From: Simon Davis
Sent: 14 October 2020 16:26
To: 'Jack Dowling' [REDACTED]
Subject: BR/122/20/OUT Garth House, High Street, Bognor Regis

Proposed First Floor Plan

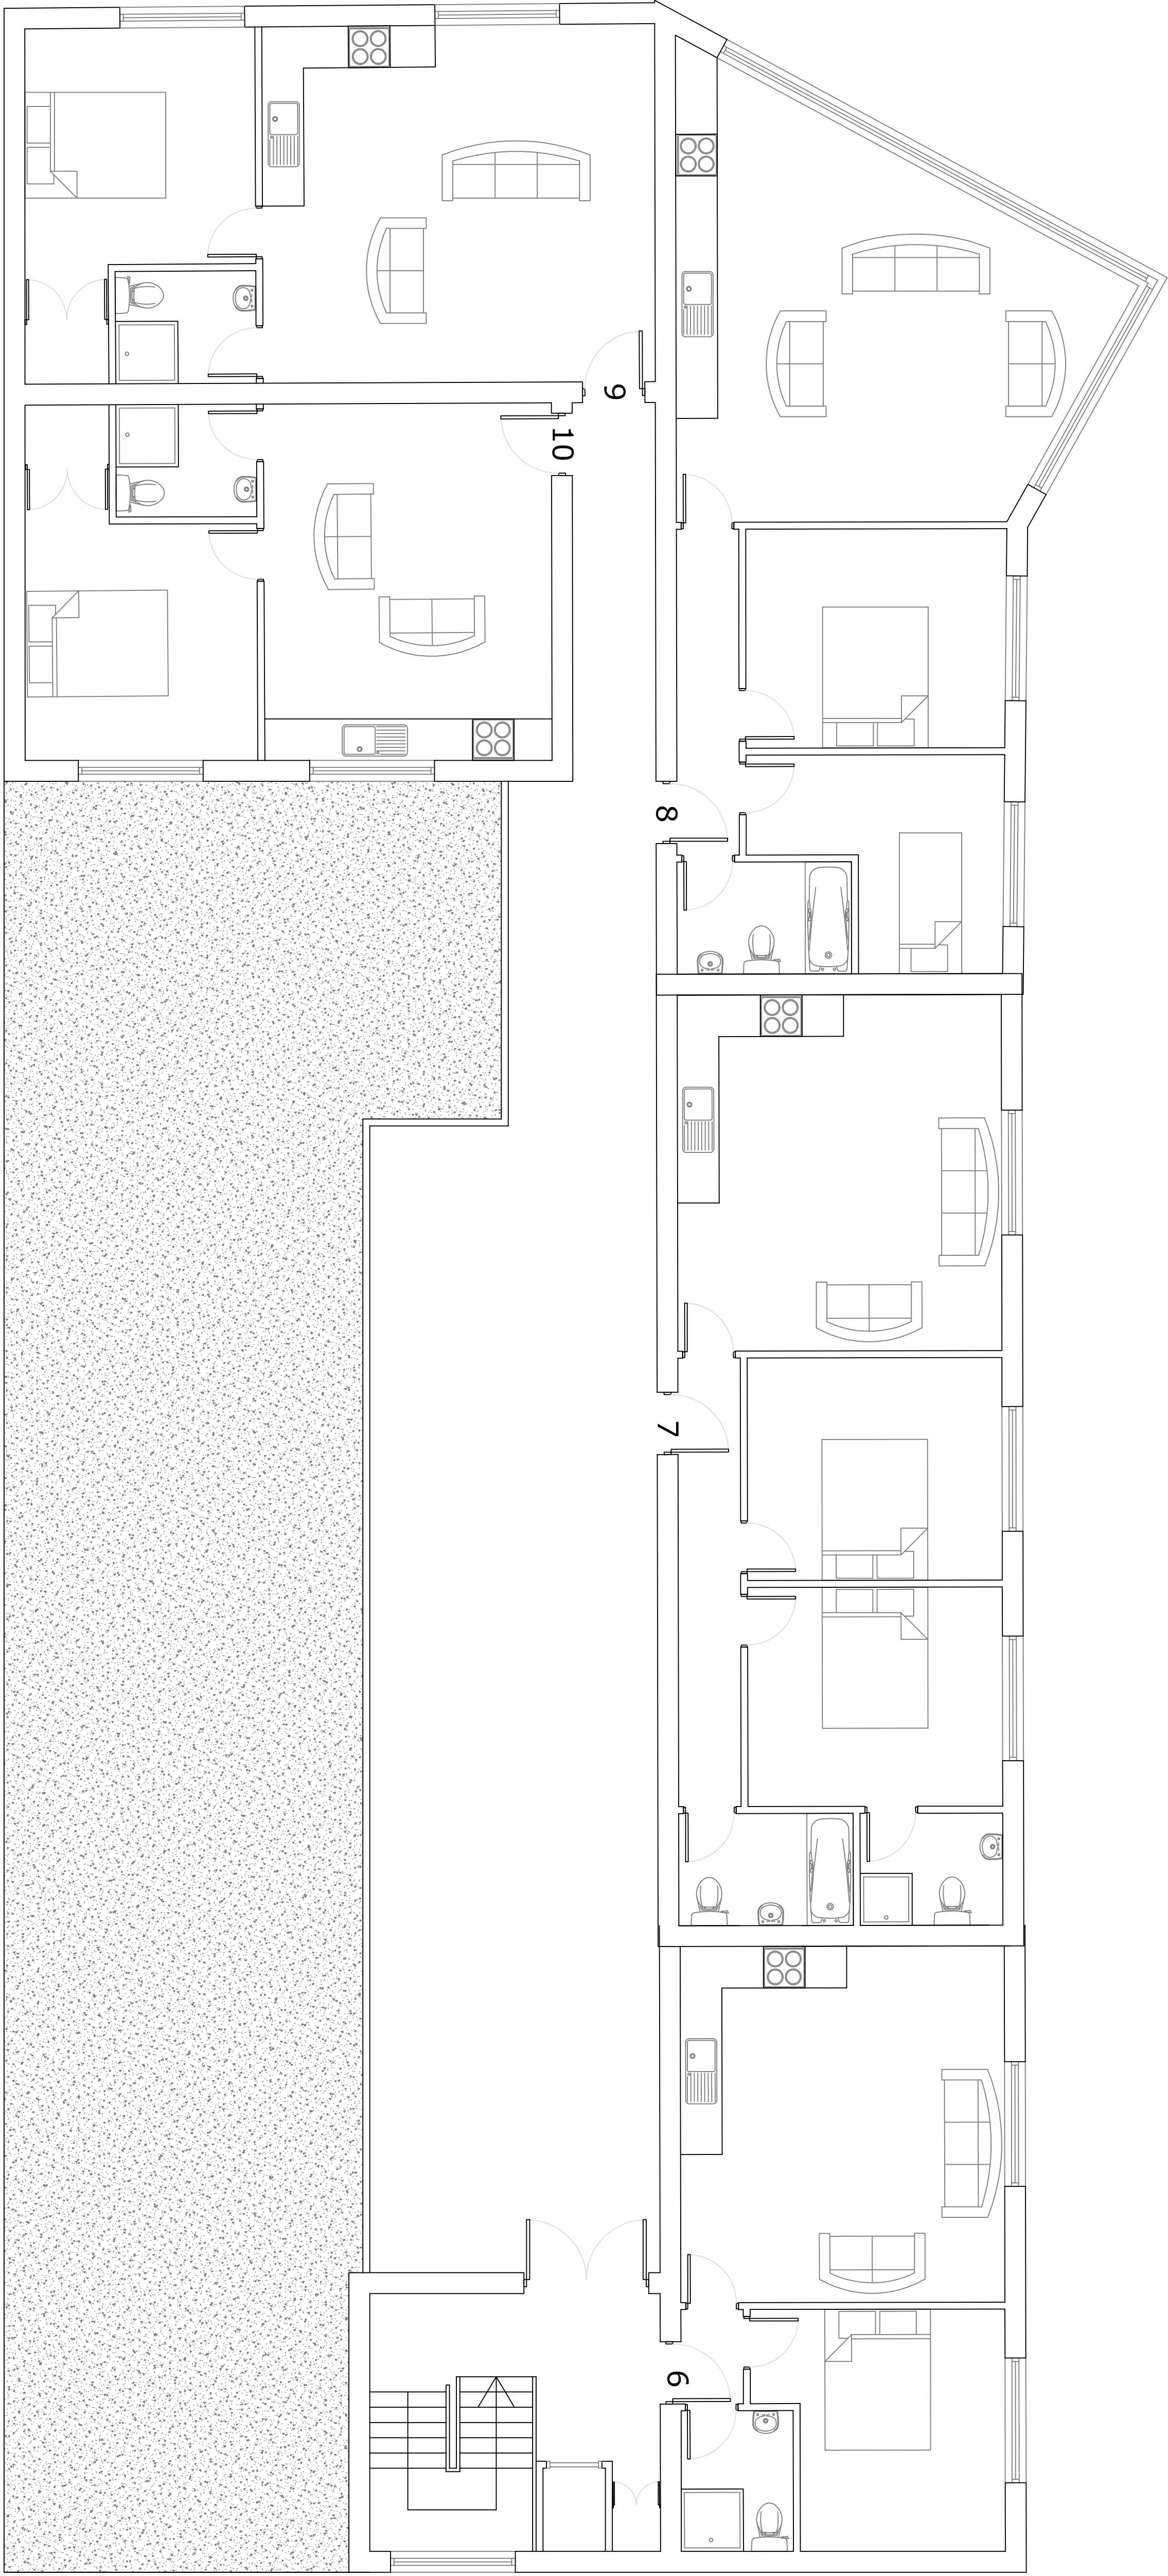
- (3) I note that the scheme suggests a partial betterment to existing residents in that the building will be only 1 storey on the western side of the site (currently it is 2). However, the new building will extend further back into the site and the eastern half will have an additional storey. Although no west facing windows are proposed, I note that doors to the flats open onto an external space which may have windows in it and offer views of neighbours. I apologise if this is not correct but without external elevations it is difficult to work out this arrangement. Also the new building is to the east and may affect light reaching the windows and gardens of the existing dwellings. It may also be considered to be overbearing.

Note that it has been somewhat difficult to precisely assess the harm to existing dwellings as to work out the distance between say the doors to the first floor flats and the rear first floor windows of 3 Campbell Road means measuring part of the distance on your floorplan and part on the block plan. I got around 22.8m but according to our GIS, the distance from the back wall of 1 Campbell Road to the eastern edge of your site is 16.31m so the measurement from the plans can't be right. It may be that the scale is wrong or the plans have not been uploaded at the right size. Could you look into this please.

Proposed Ground Floor Plan

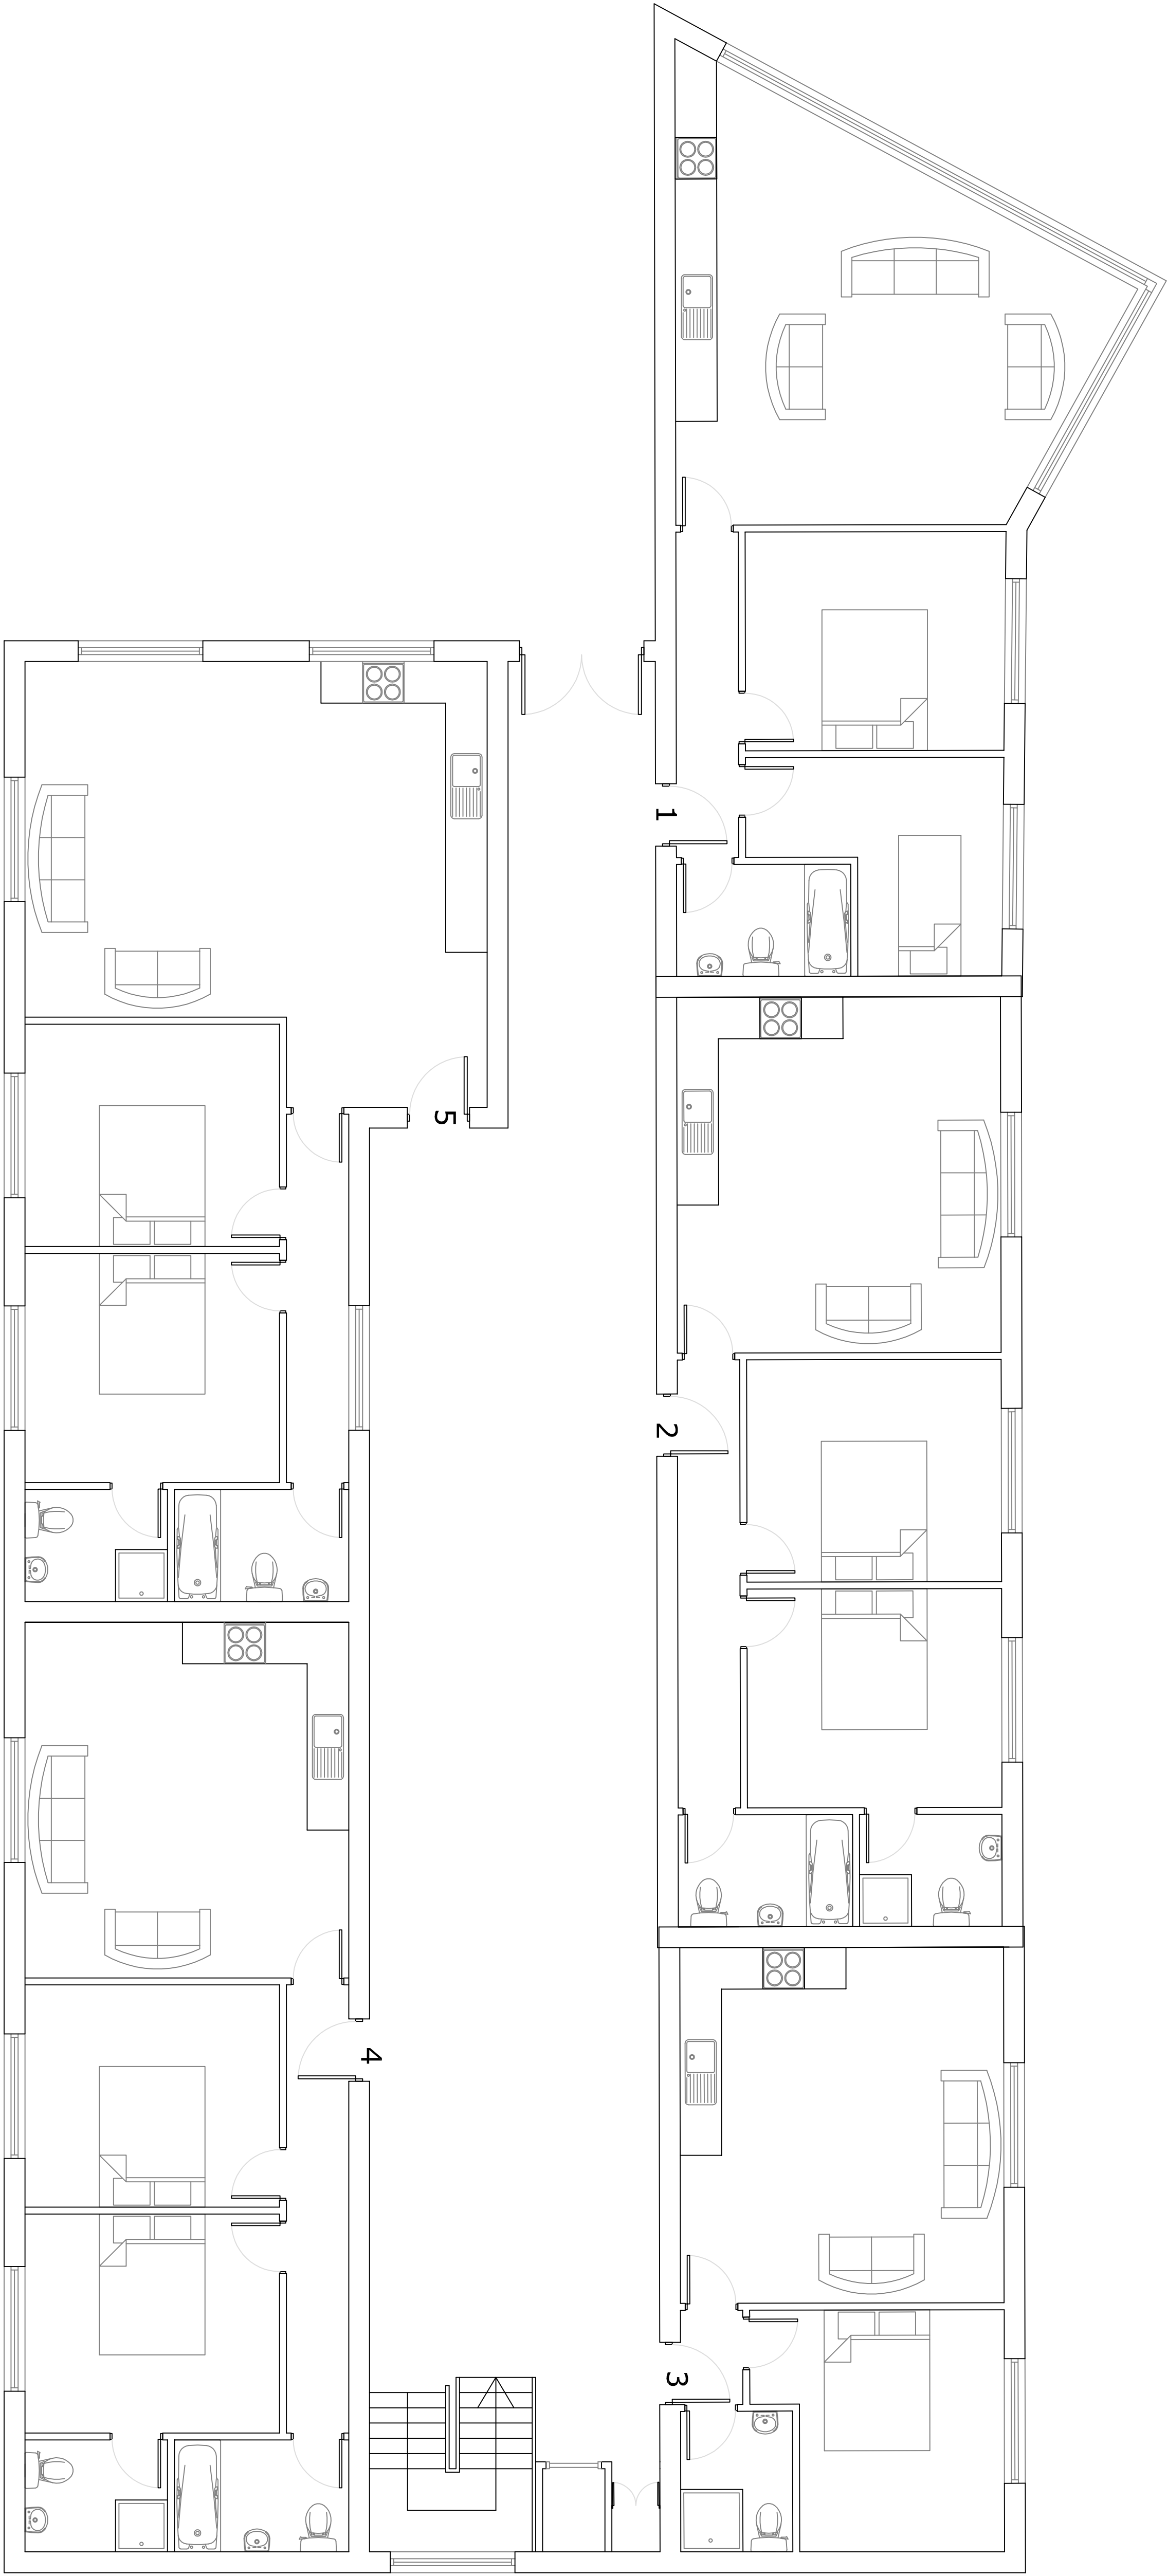
- (1) The proposal develops the whole plot with no space left for private amenity (note that the emerging Design Guide requires private amenity space for flats in the form of 3m² balconies/patios or a communal space of 40m² + 10m² per flat not having a balcony/patio).

- (2) The lack of space within the site means that the cycle and bin stores are on the front and this may be harmful to visual amenity/the streetscene.
